## Executive Summary

**Project:** Bob's Burgers (305 Eubank Blvd. NE, Albuquerque NM 87123)

**RE:** TCL Executive Summary

A1 TRAFFIC CONTROL LAYOUT

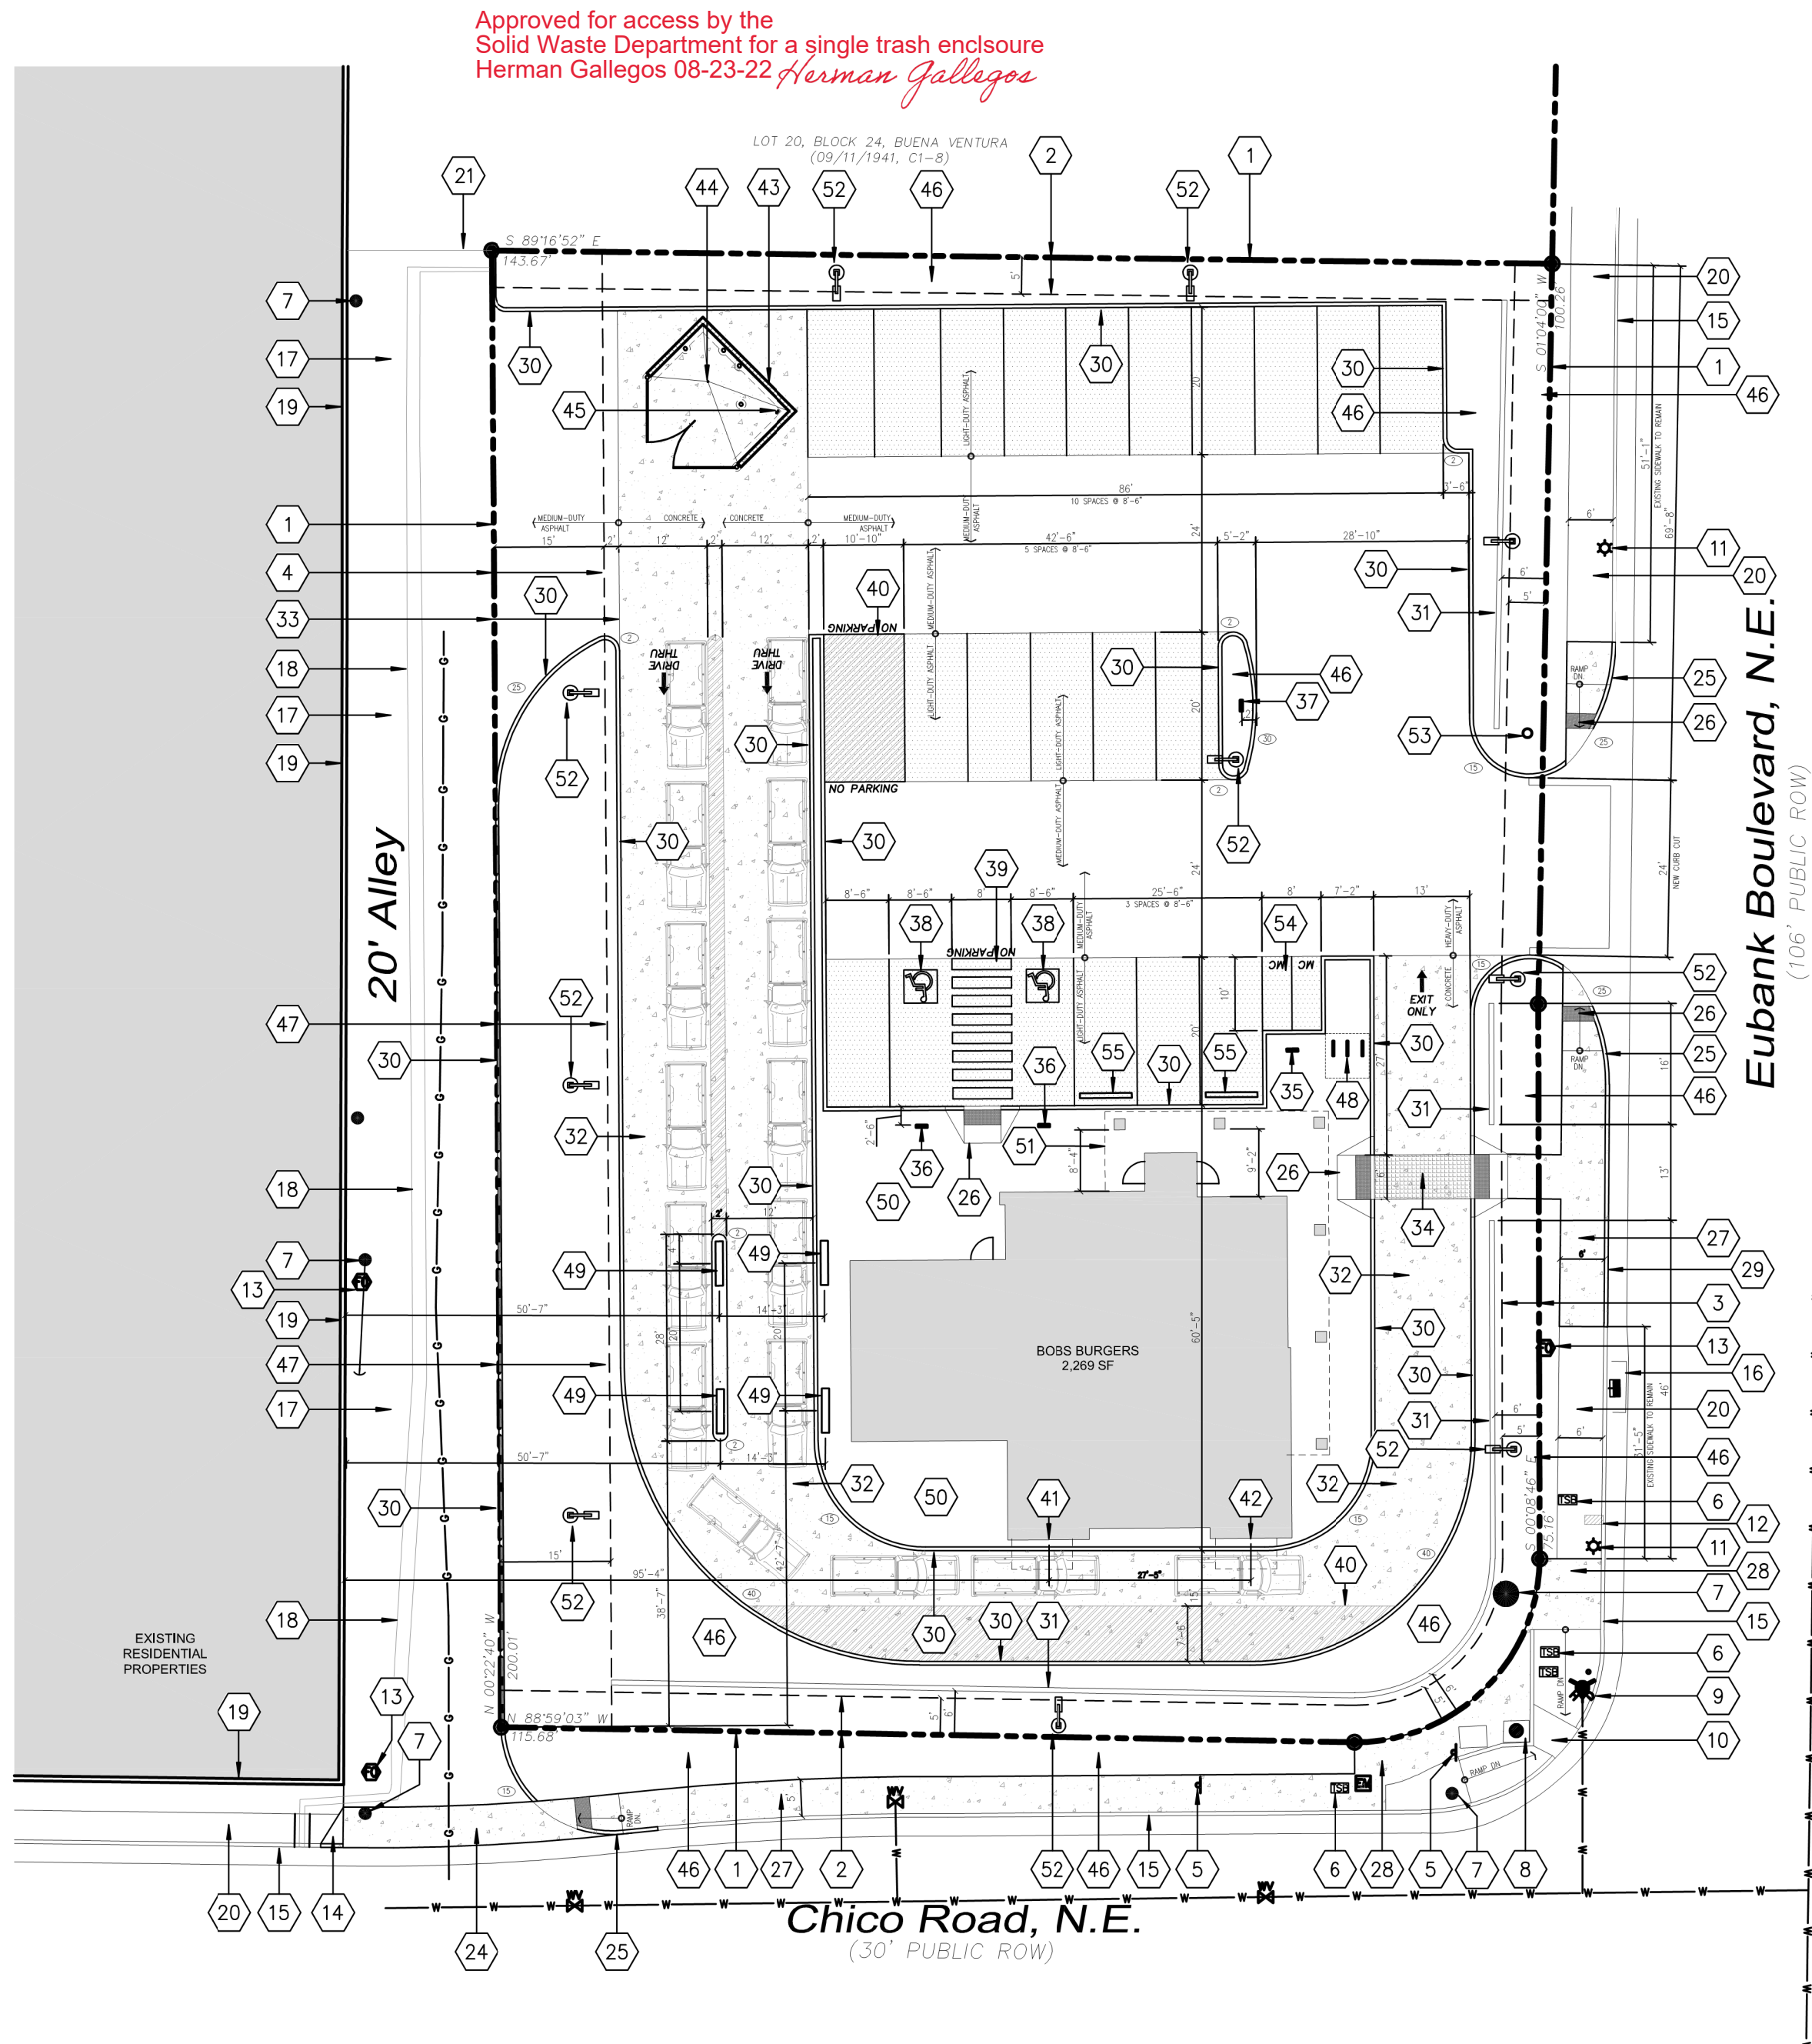
Q: Jeanne asked that we provide a rounded entry from Chico into the Alley.

We have added/infilled new concrete at the corner of Eubank and Chico to ensure at least 4' minimum clearance around all existing obstacles including the existing streetlights and existing traffic signals. We have left the existing handicap access ramp to remain at this corner. There is not a way to rebuild this ramp to COA standards without relocating the traffic signal mast arms and a PNM power pole as well as an existing fire hydrant. We have left the existing ramp without modification and have infilled behind to allow proper circulation clearances around the obstacles.

Jeanne had some circulation adjustments to the plan. Those have been met and are represented on the TCL.

A: The alley is obstructed on the west side of the existing curb cut by a power pole and an inground communications vault as well as existing CMU site wall from the property owner at that location. These items are located within the clear sight triangle. Due to these obstacles, we are unable to comply with the request on the west side of that drive pad entry. We have left those existing conditions in place. We did however modify the East side of that drive pad to comply with the request. The standard DPM clear site triangle is applicable to the East of the access point. During our meeting Jeanne recognized the existing limitations and was agreeable to our proposed solutions at that drive access.
